From: Carol Reynolds
Sent: 19 April 2018 12:47
To: Michael Eastham
Subject: RE: LU/121/17/RES - Phase 2 - North Littlehampton Strategic Development Area (SDA)

Dear Michael,
I am so sorry that I must refer this back for further action yet again.
P16, Plot 82-86, please can the applicant make it clear that those bedrooms which face the central link road require noise mitigation.

Please find attached the amended report to discharge conditions 37 and 38 - Noise.

Anomalies persist in page 16 and 17 of the Wyg Noise Report dated February 2018. That last paragraph to page 16 detailing the location of sensitive receptors needs correction in that:-

SK02 Site Layout and Receptor Locations

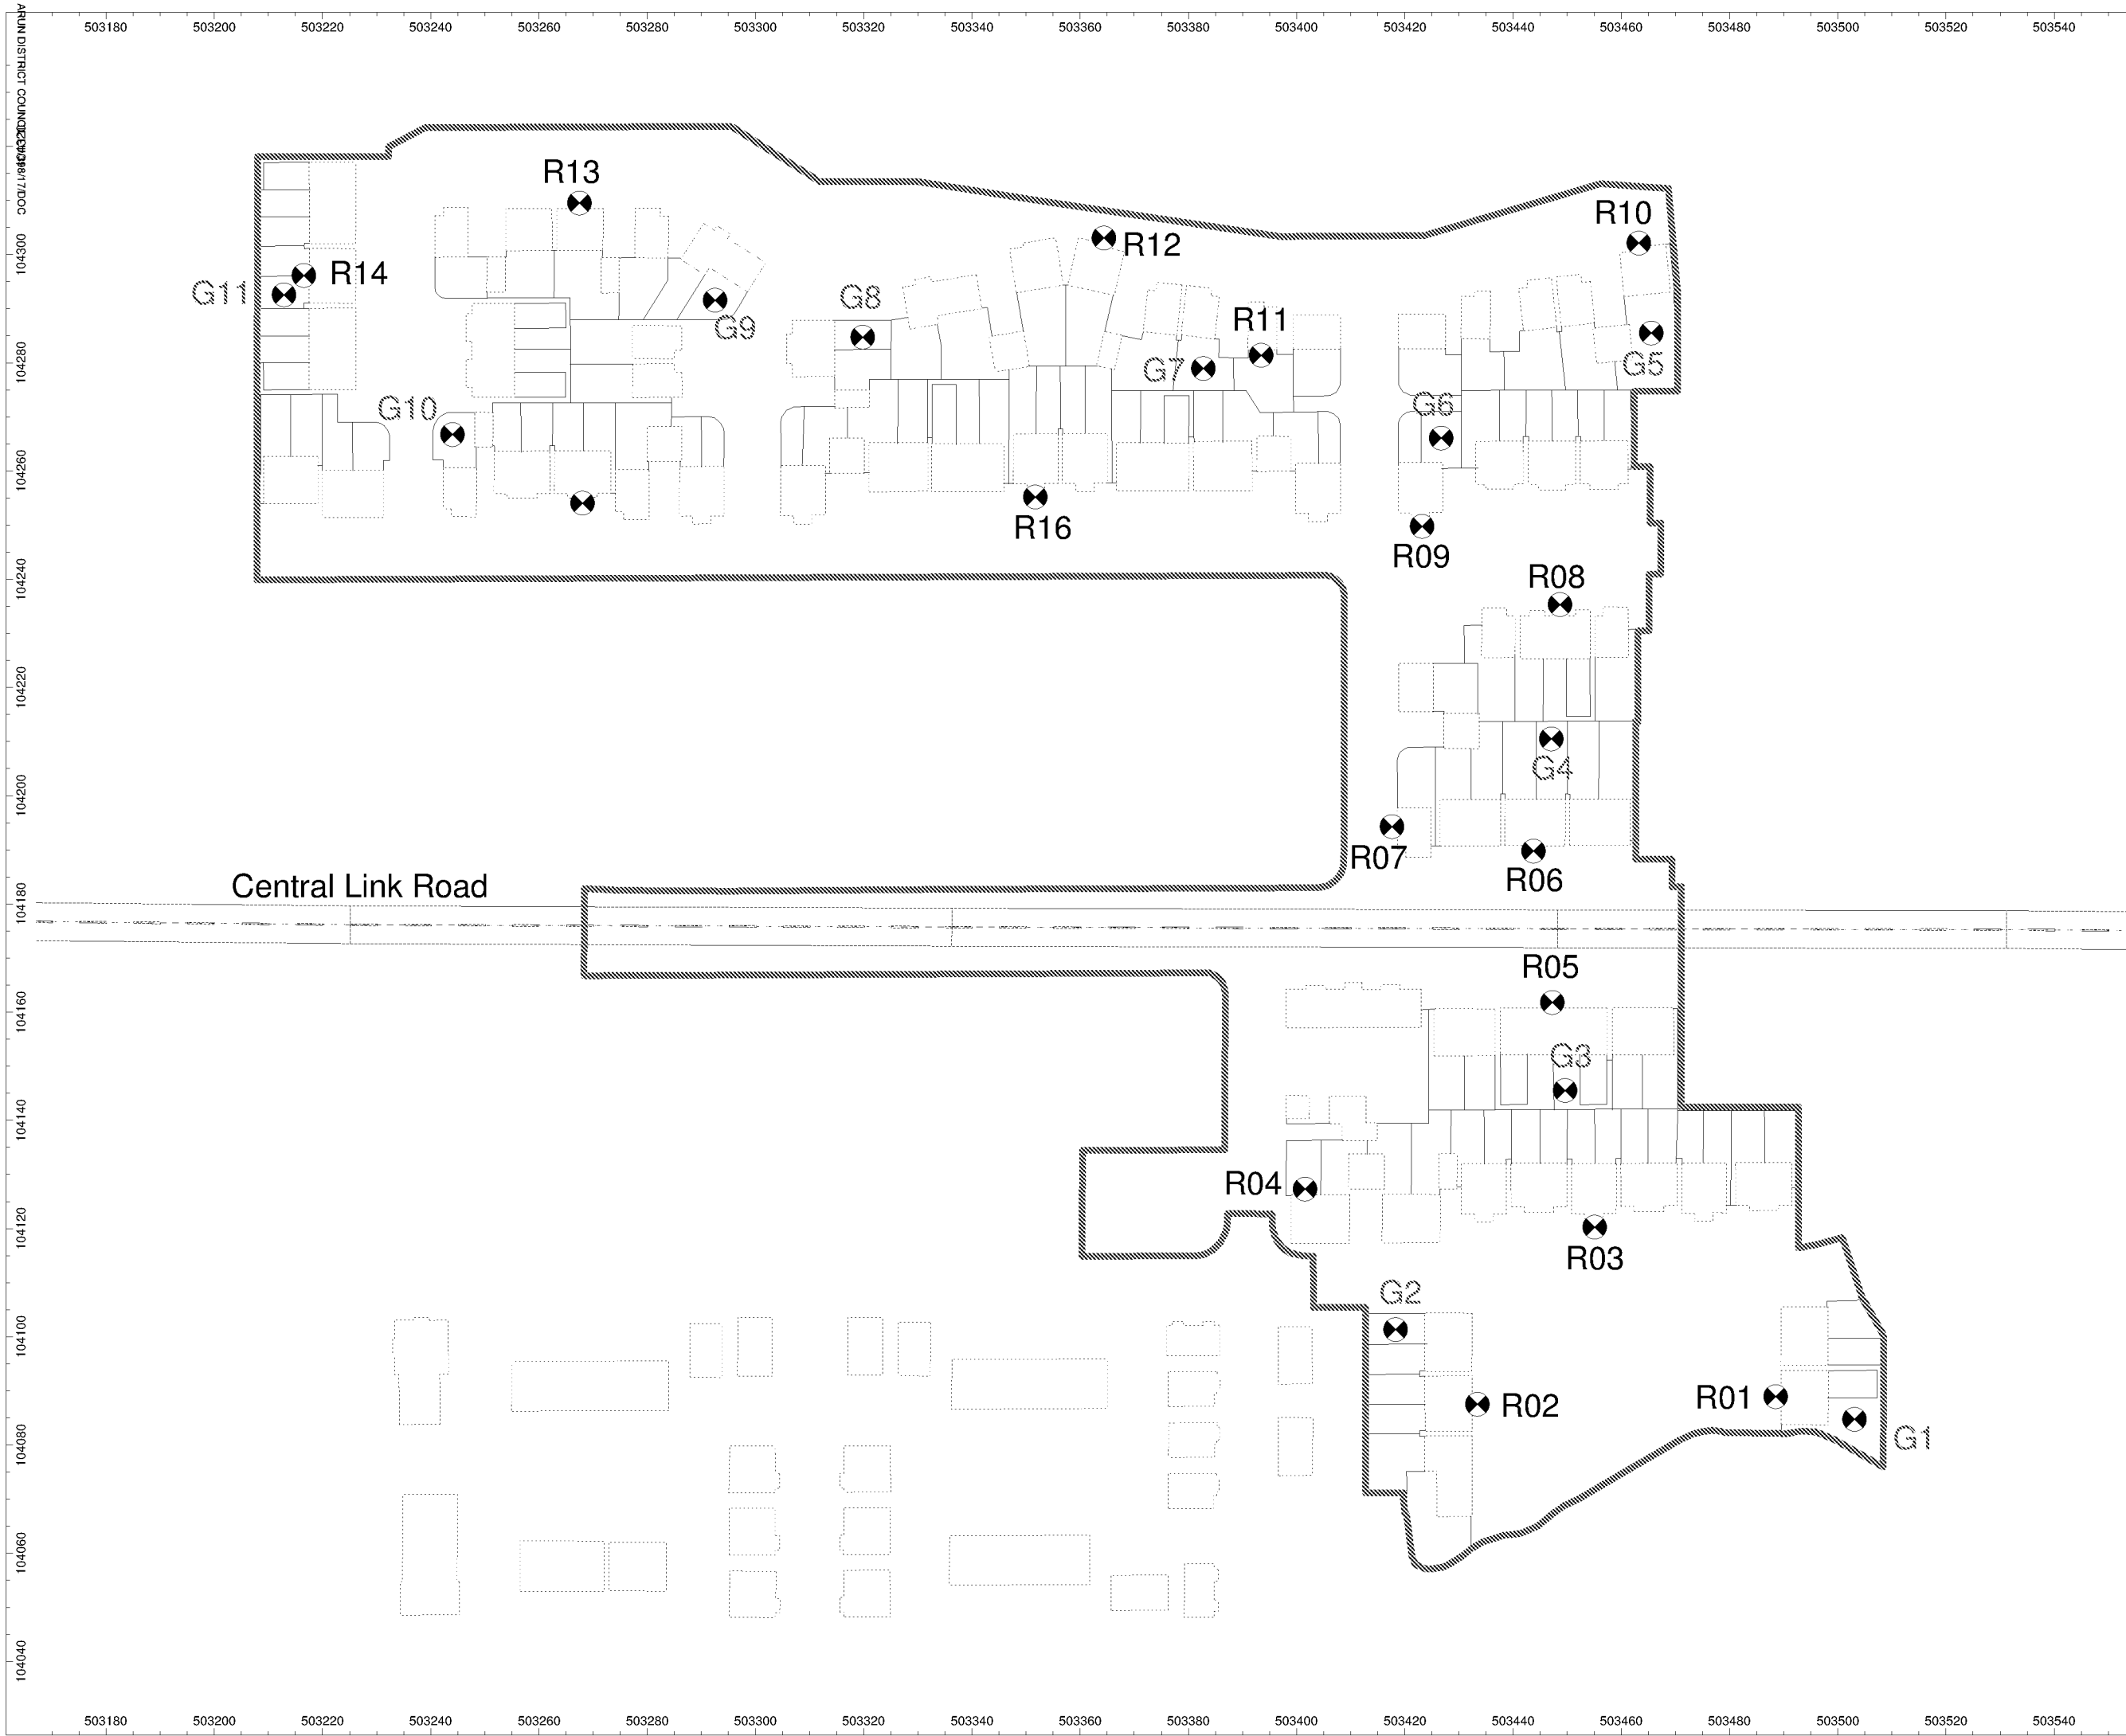
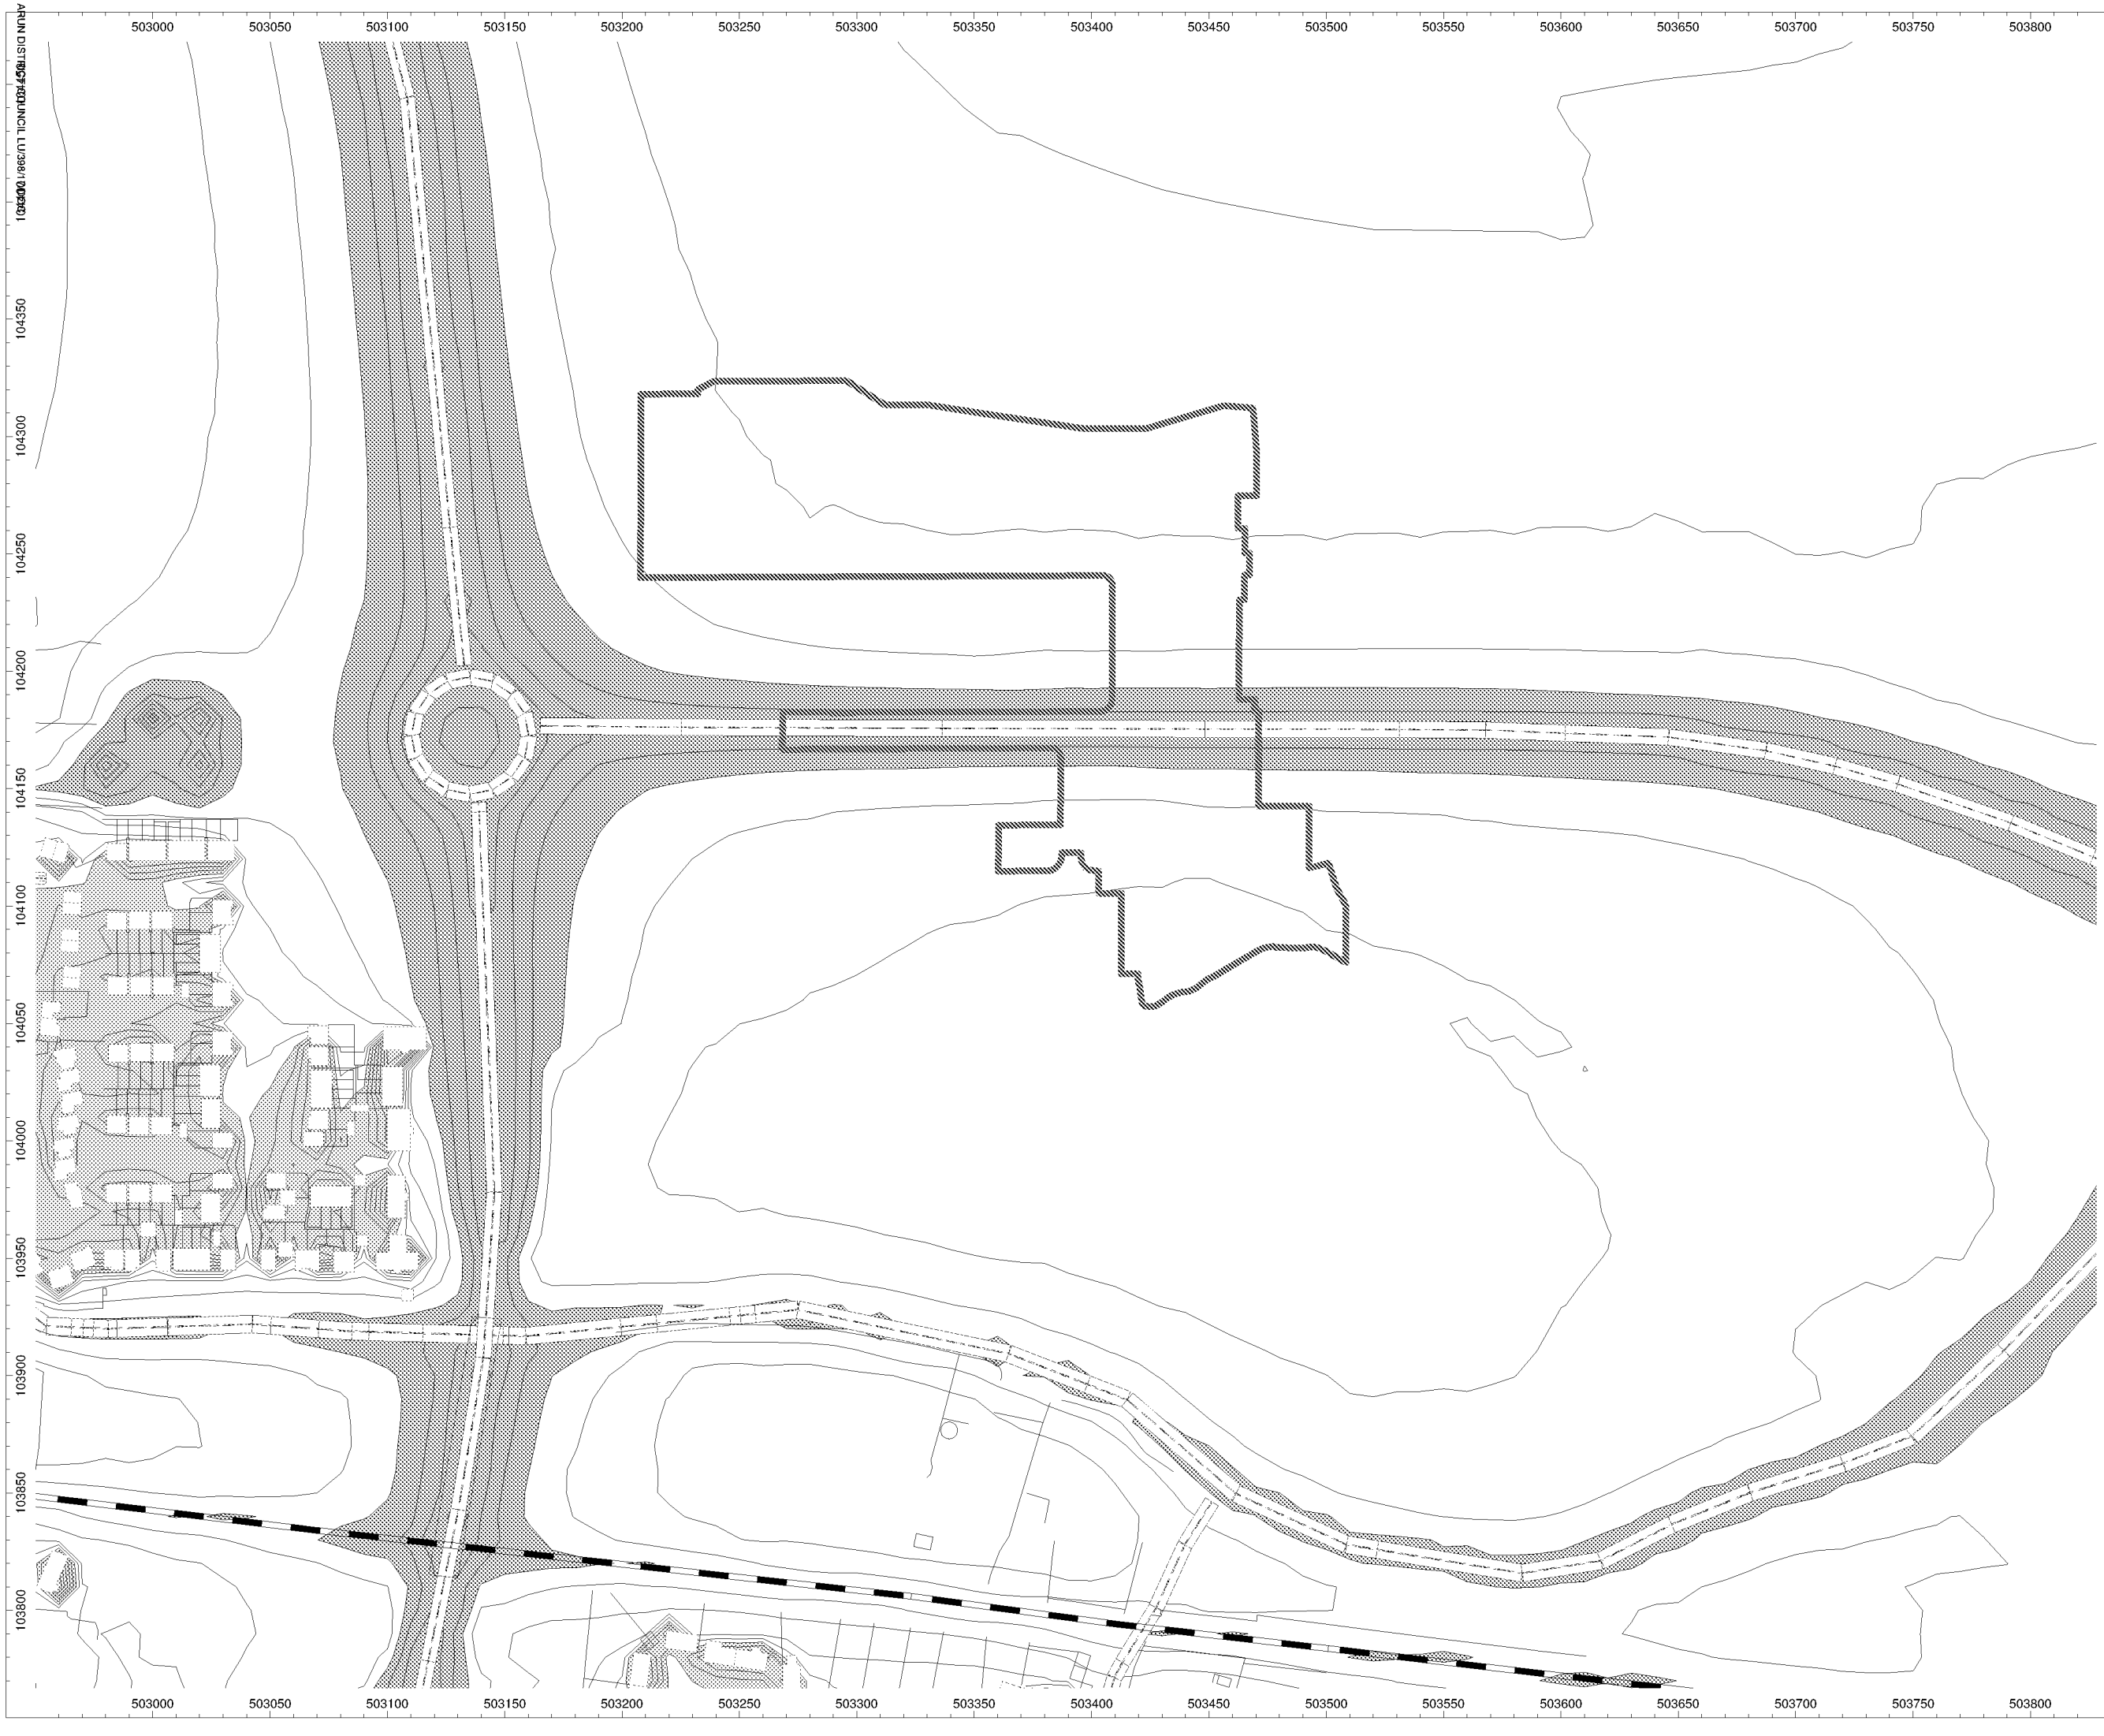
Plot 82-86: The applicant has referred to living rooms being shielded. He has omitted the fact that sensitive rooms ie the bedrooms are exposed to the effect of the Central Link Road. This detail should be added in.

Plots 99-100. These consist flats 95-100. Whereas it is stated that bedrooms are exposed to the effects of the Central Link Road this should be adjusted to include bedrooms **AND living rooms**.
